**From:** Martin Hill  
**Sent:** 08 September 2020 11:55  
**To:** Planning.Responses  
**Subject:** RE: Planning Consultation on: AW/222/20/PD

Comments from Private Sector Housing:

**Application No:** AW/222/20/PD

**Description of Works:** Prior approval under Schedule 2, Part 3 Class M for the change of use of barber shop to 1 No. dwelling.

16/A ROSE GREEN ROAD		
BOGNOR REGIS PO213ET		
FIRST FLOOR	SCALE 1:50	
DRAWING REF : 001	DATE	24/8/20

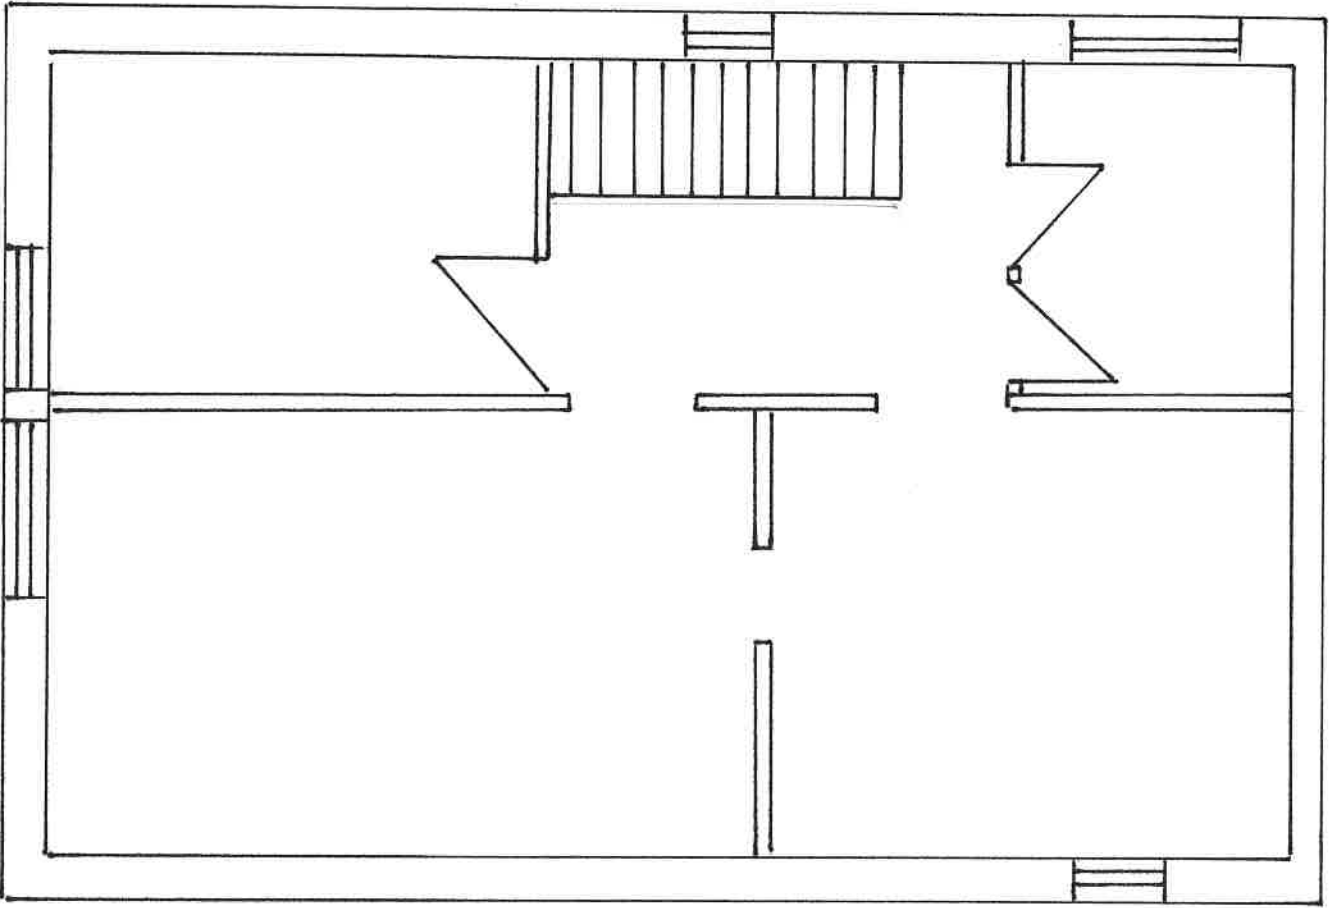
According to the application, this consultation appears to relate to 16A Rose Green Road and not 14A Rose Green Road.

- There should be adequate fire separation between the ground and first floors. Where the ground floor is a commercial undertaking, a minimum 1 hours’ fire resistance must be afforded between the commercial and residential units. Where this cannot be achieved, a suitable interlinked fire alarm and detection system must be installed, having had a suitable and sufficient Fire Risk Assessment undertaken by a competent person.

- Bedrooms must be fitted with a close fitting conventional door. The kitchen and lounge areas opening on to the escape route must be fitted with a close fitting conventional door. It is unclear from the plans the intended purpose of each room.
